**RE: APPLICATION TO MODIFY THE PROJECT APPROVAL FOR A MIXED USE
DEVELOPMENT ON THE THOMAS STREET CAR PARK SITE IN CHATSWOOD (MP09_0066
MODIFICATION 6)
FURTHER SUBMISSION ON REVISED PLANS**

Willoughby Council made a submission to the Department on proposed Modification 6 by Meriton Group to MP09_0066 by letter dated 27 March 2013.

GROUND FLOOR PLAN

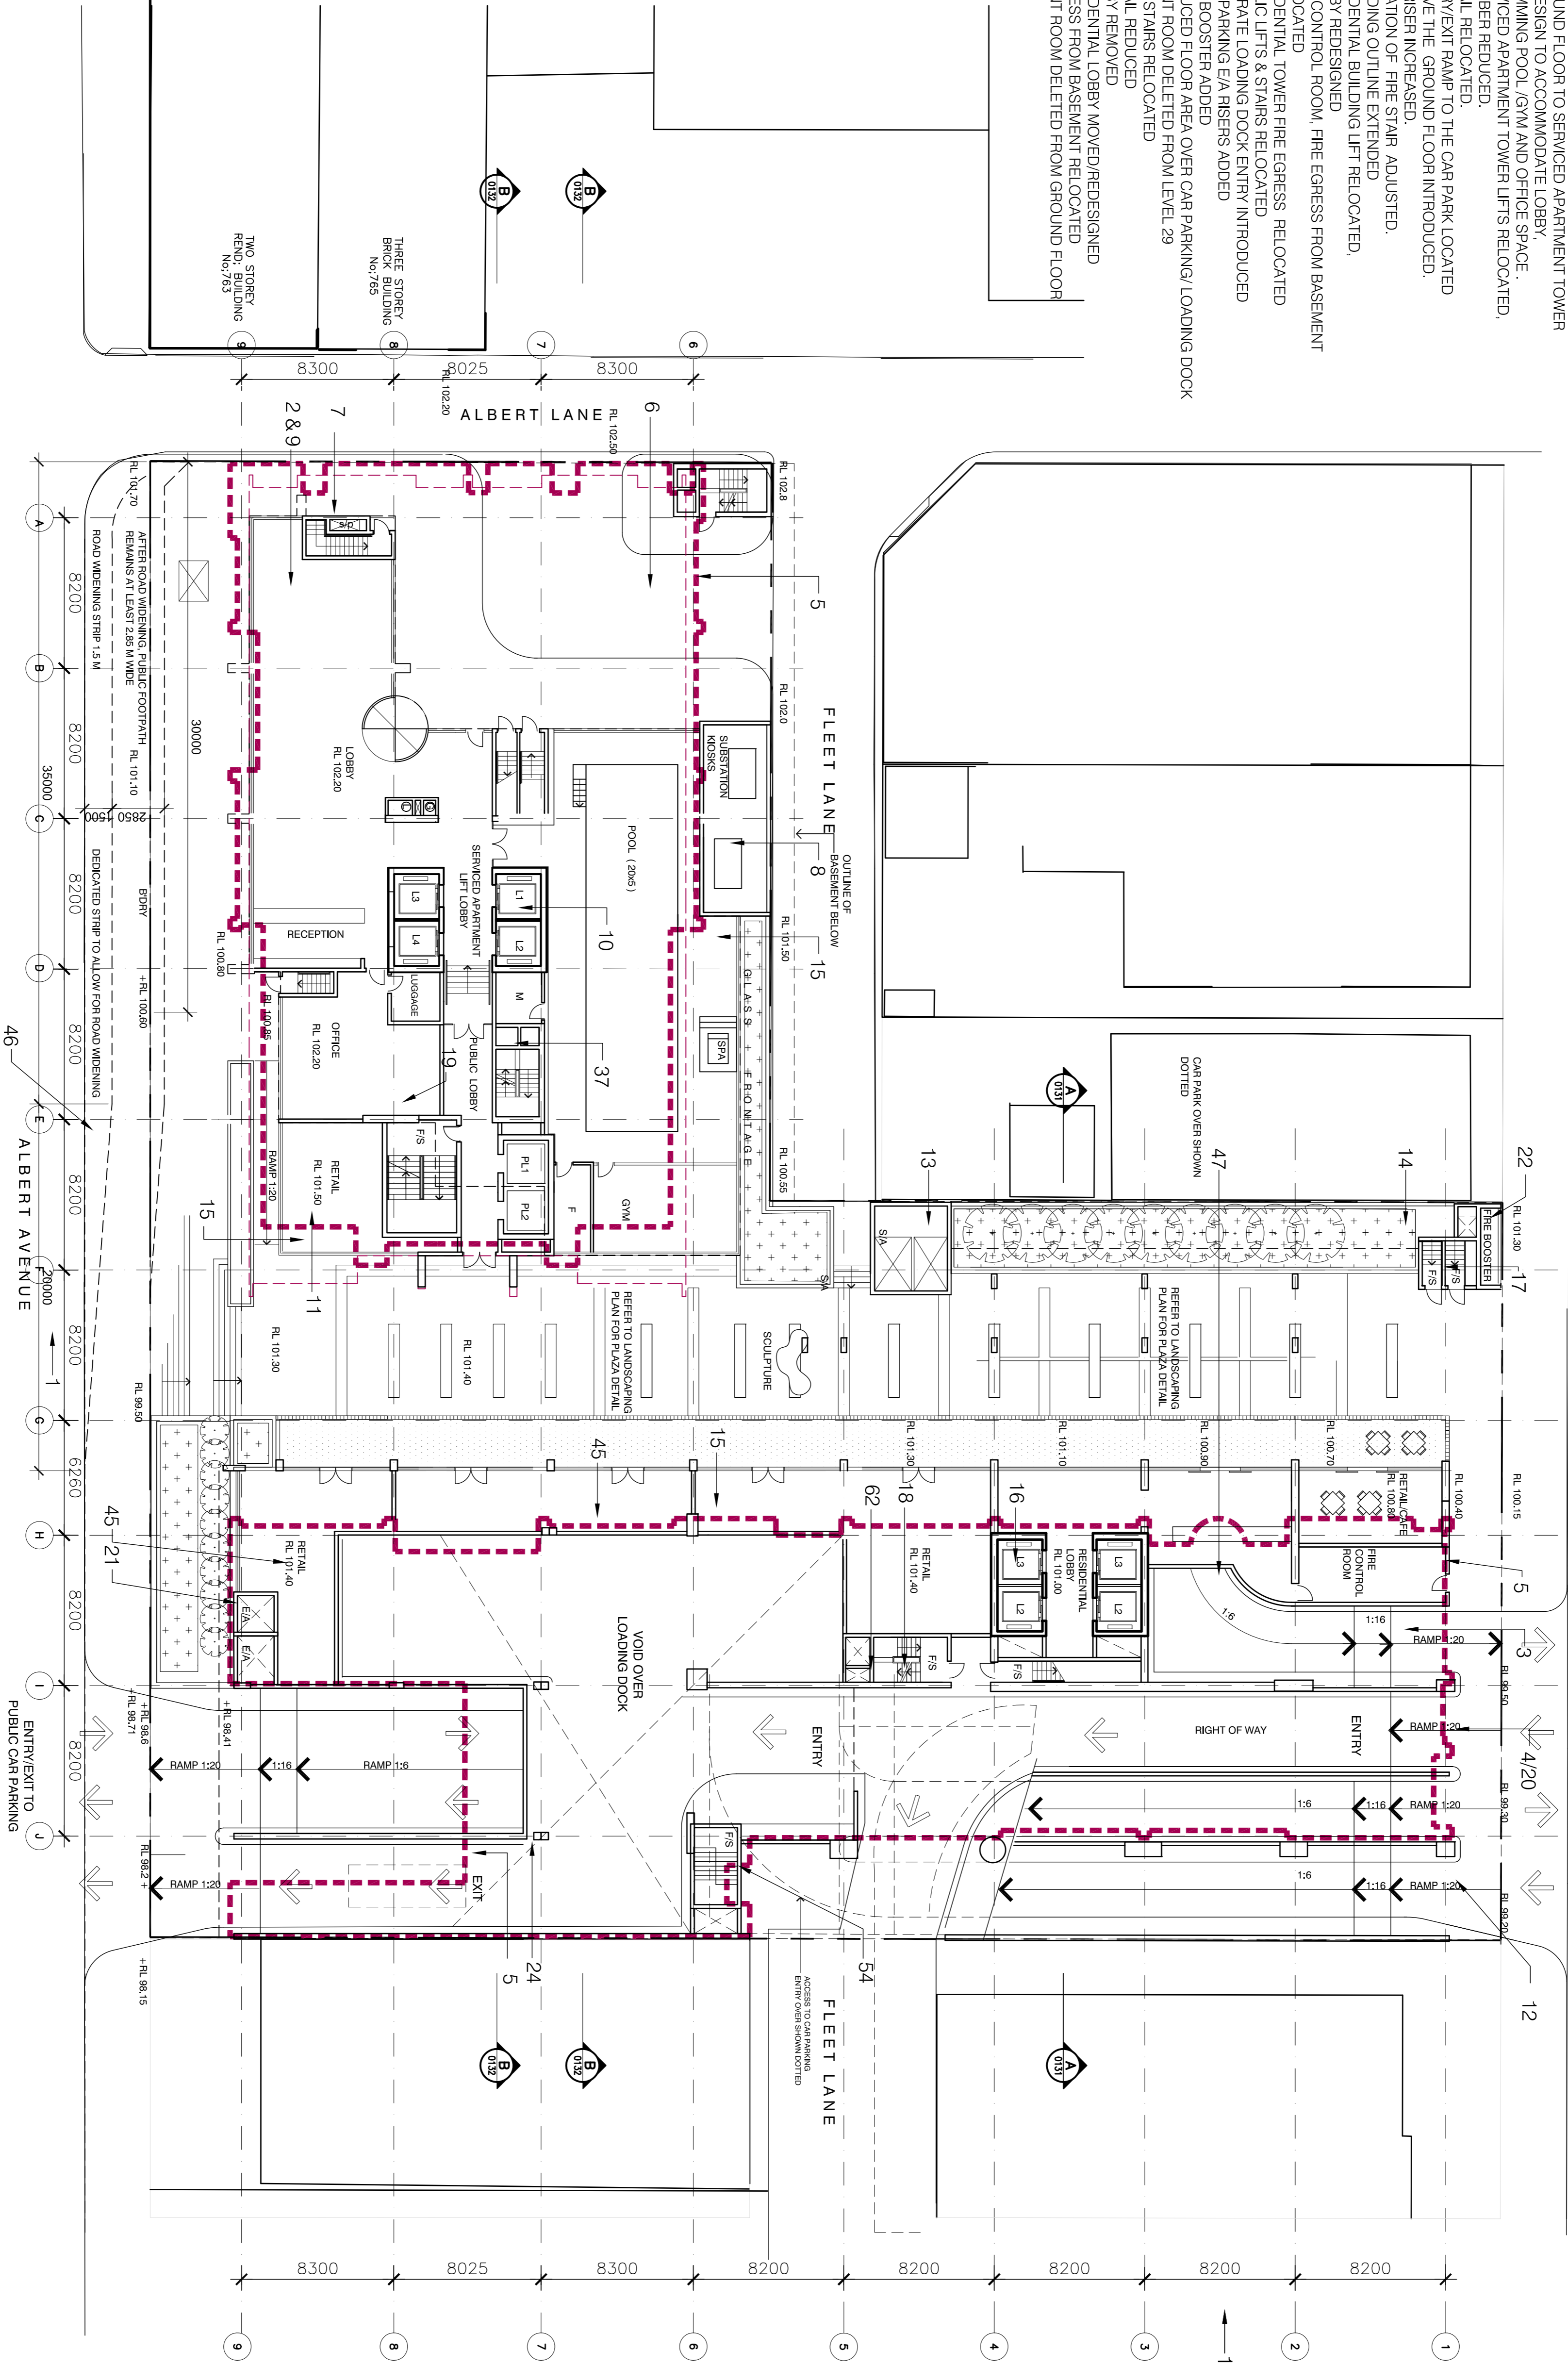
1. A 50 place child care centre along with designated parking / drop off space for the centre and additional lift access.
2. Adjustment of the serviced apartment porte-cochere to include a parking lane and a drive through lane;

9. Adjustment of fire stairs and fire control room to improve the entry to the landscaped walkway.
10. Alteration of the retail space at ground floor in the light of 8 and 9 above.

5. Identification of the affordable housing units;
6. The driveway crossing in Thomas Street should provide tactile paving at the foot path crossing points, use of a paver treatment where the foot path crossings occur (instead of concrete), additional lighting over the entrance points and a coherent signage plan for the 4 driveways indicating purpose and flow direction of each path;

12. Provision of a disabled persons pedestrian access from the public car park to the front of No 12 Thomas Street by:
 - a. modification of the ground floor to create a new pedestrian access between the open walkway, through the proposed retail lift lobby, across the covered right of way and then by a path beside the right of way to Fleet Lane at the rear of No 12, including signage, line-marking and bollards; and
